ENG-CDR21010-R3-CDs-Vollmer-North.pdf Markup Summary

VOLLMER ROAD (NORTH)
ROADWAY PLAN & PROFILE

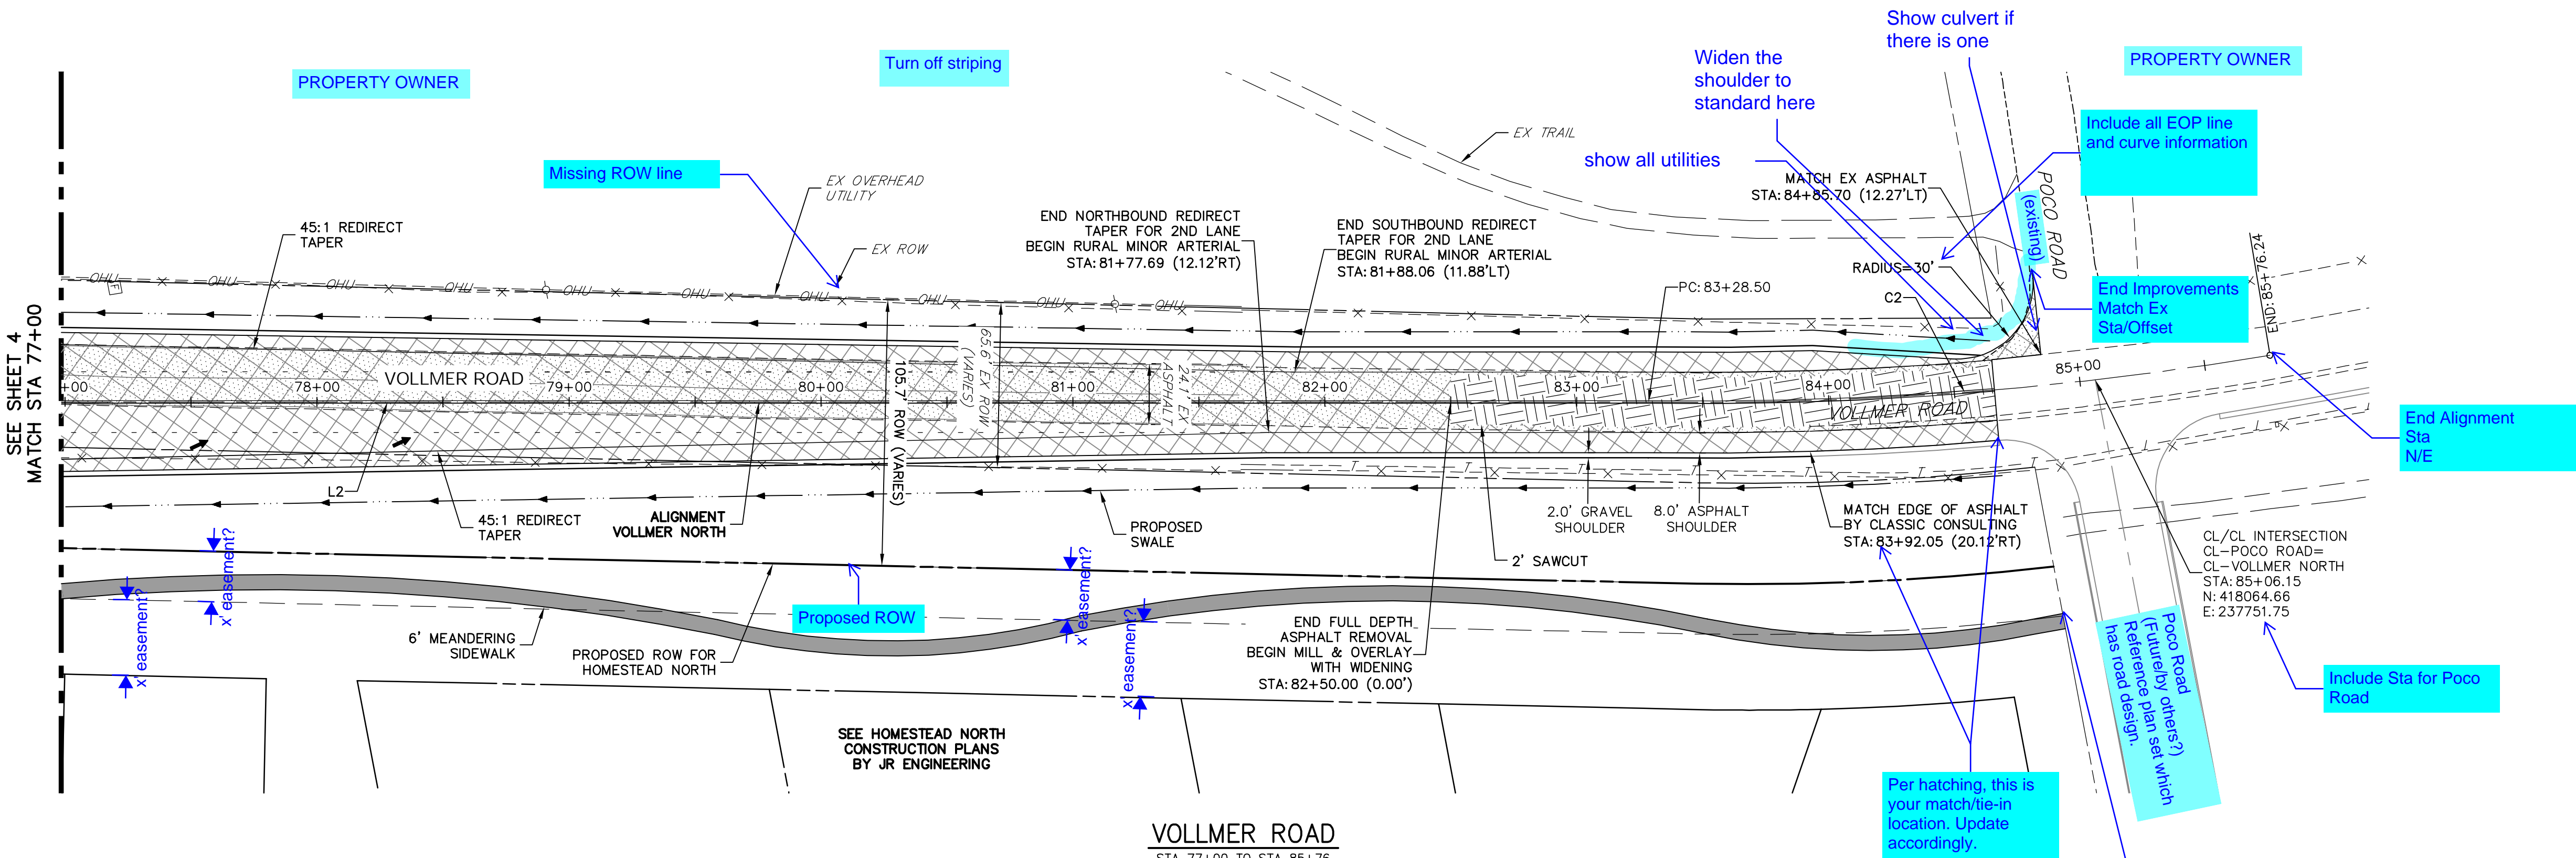
Label this line

Turn of striping. Show on signing & striping plan

Label line

Label lines

Turn off striping. Show on signing & striping plan

Label cl-cl intersection

VOLLMER NORTH PROFILE (3)
STA 77+00.00 TO 85+00.00

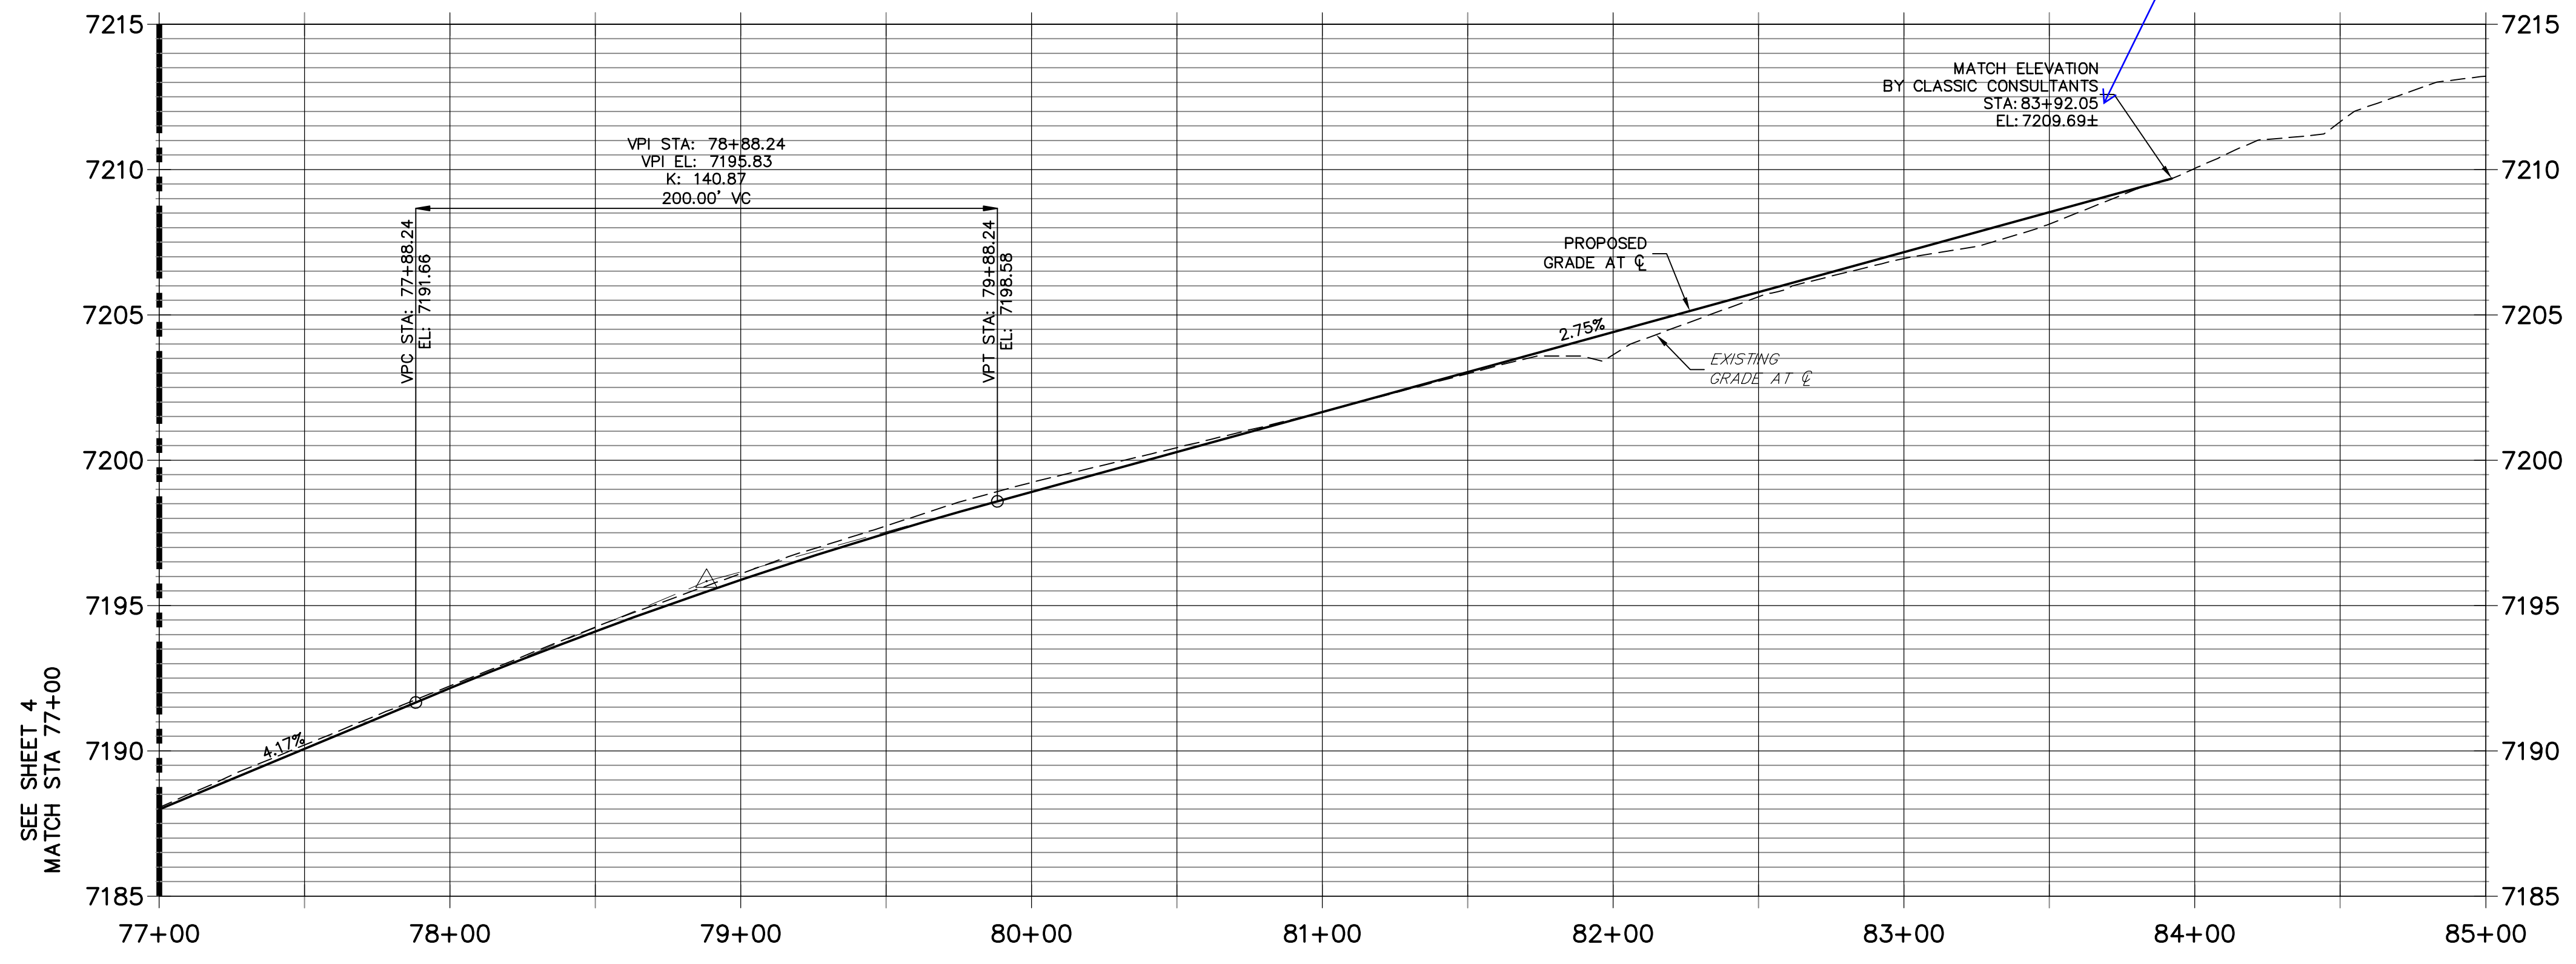
Turn off striping. Show on signing & striping plan

Label these lines

Label match point

VOLLMER ROAD (NORTH)
 SIGNAGE & STRIPING

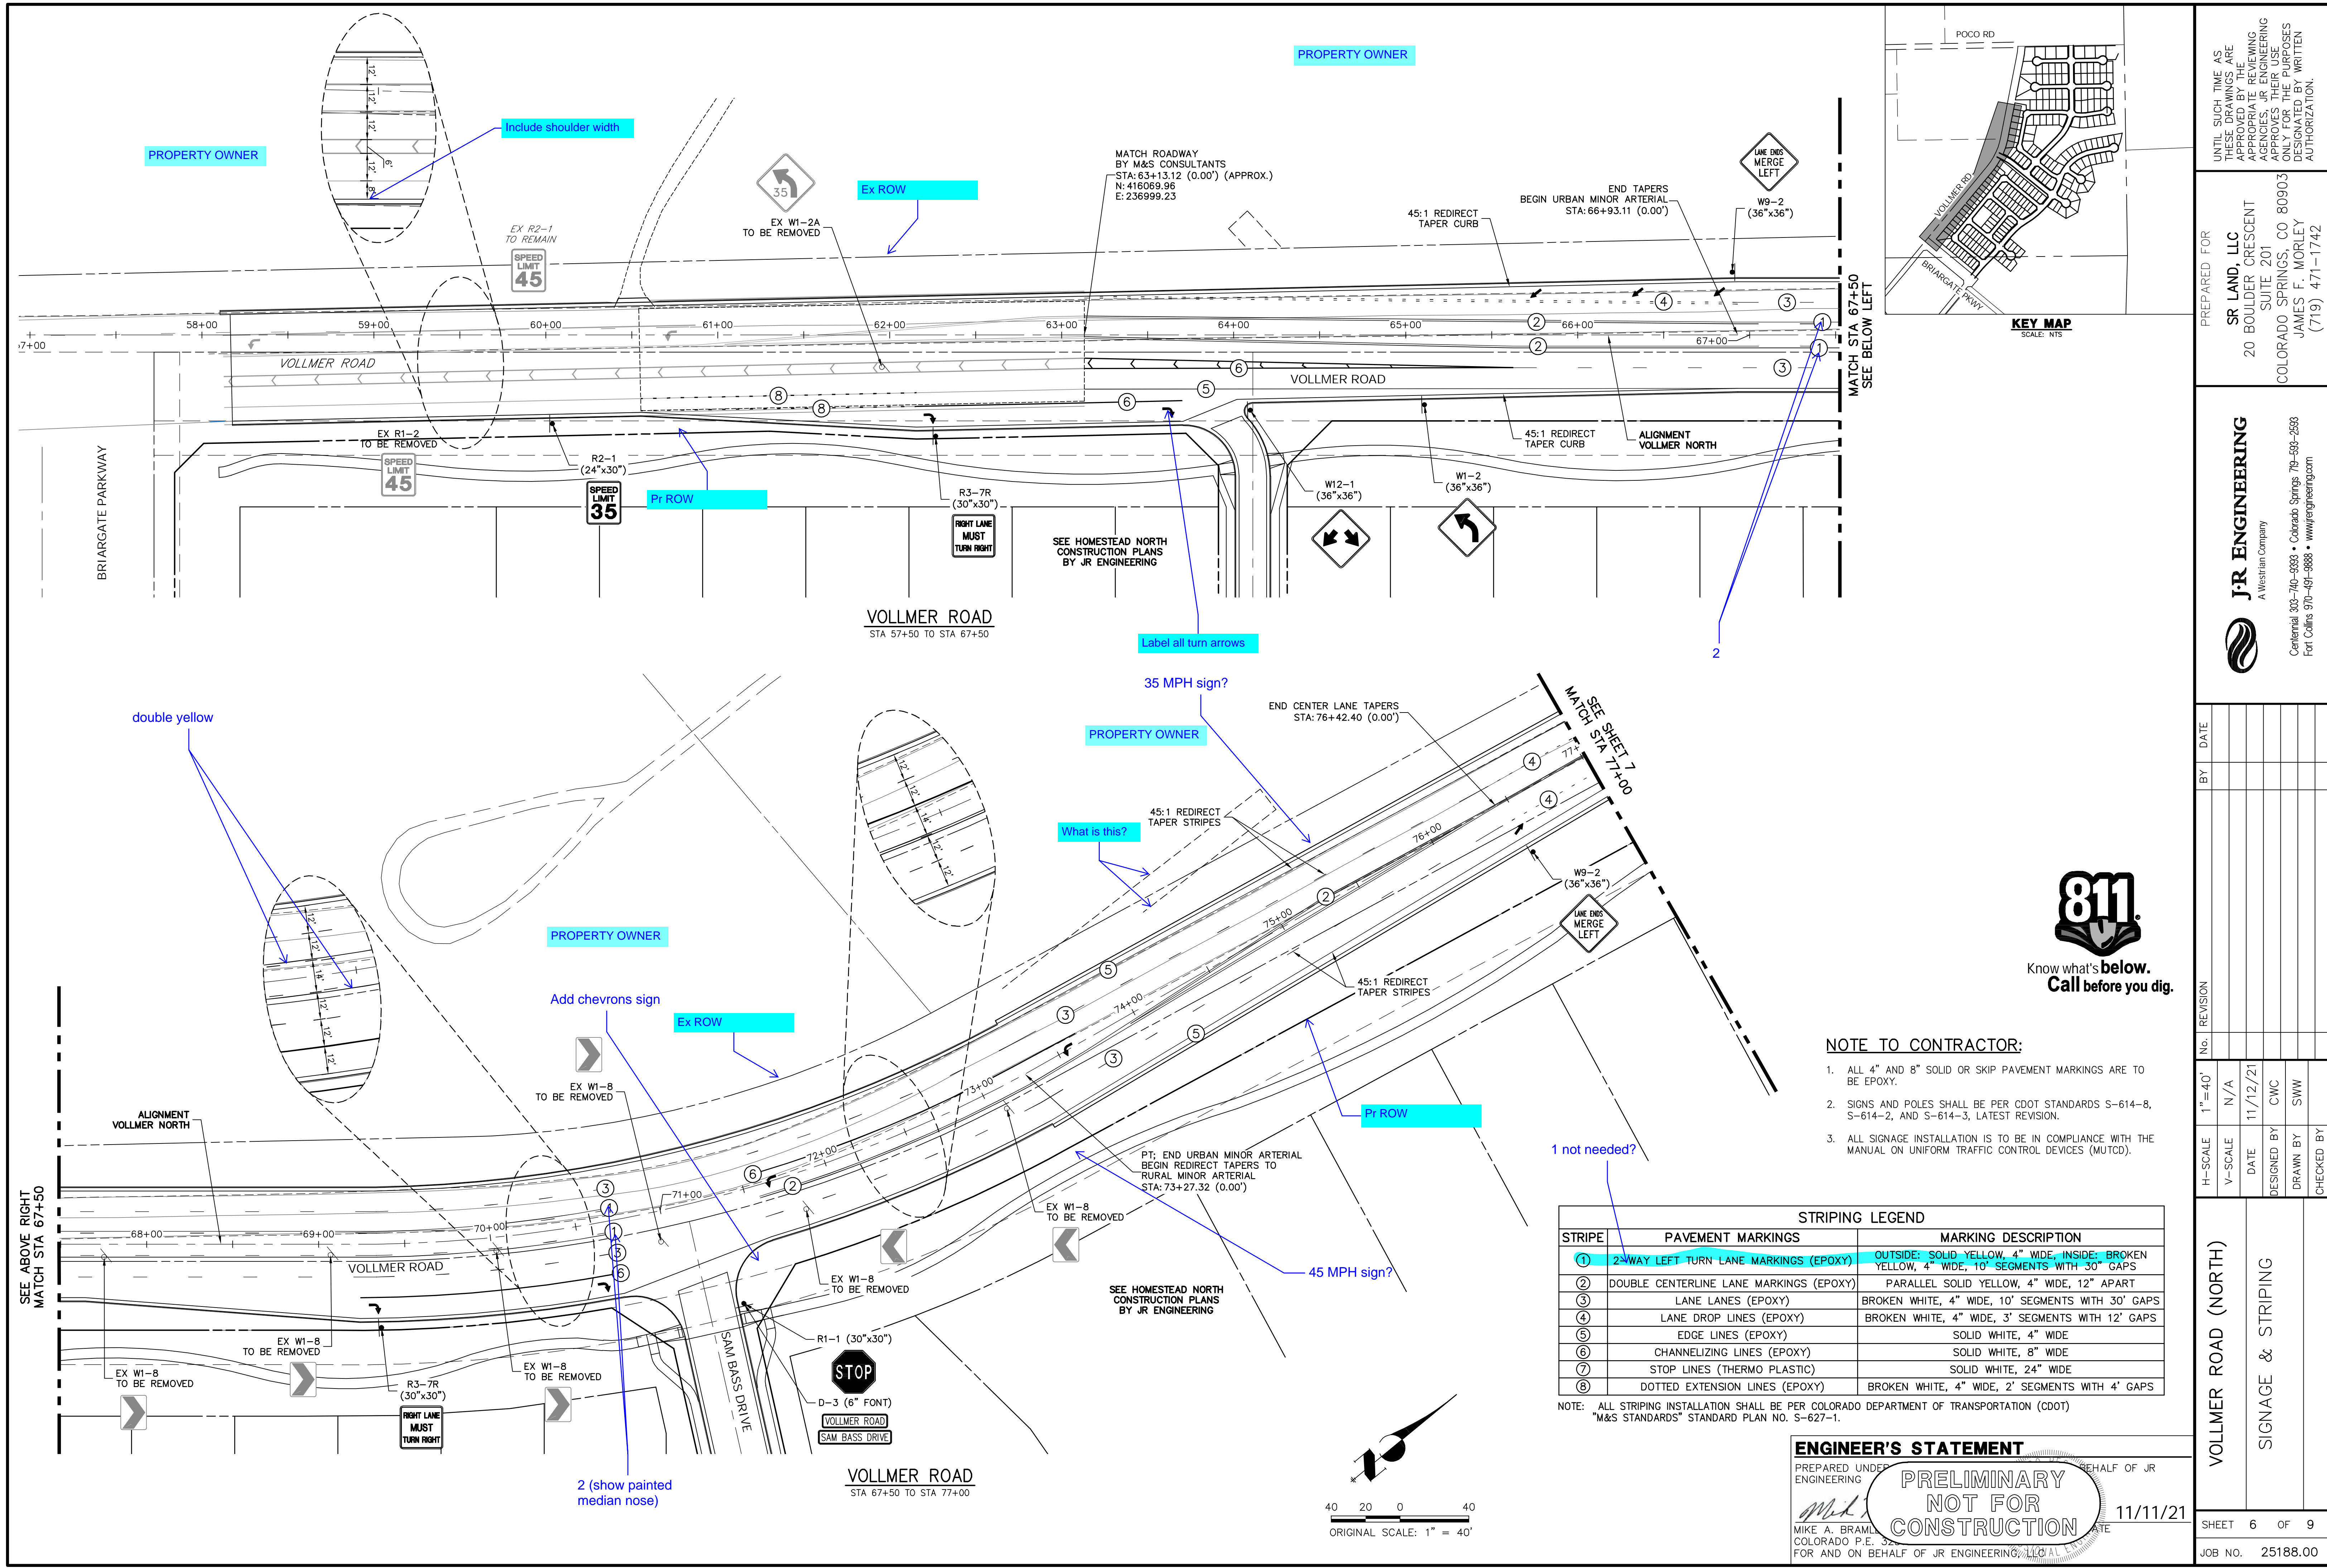
Label all proposed turn arrows

Missing sign label

Add chevron signs around curve. Check MUTCD for guidance in placement

Check for posted speed prior to new construction. If 55 mph, will need to have 45 mph sign at beginning of new construction (see next sheet) then 35 mph sign here
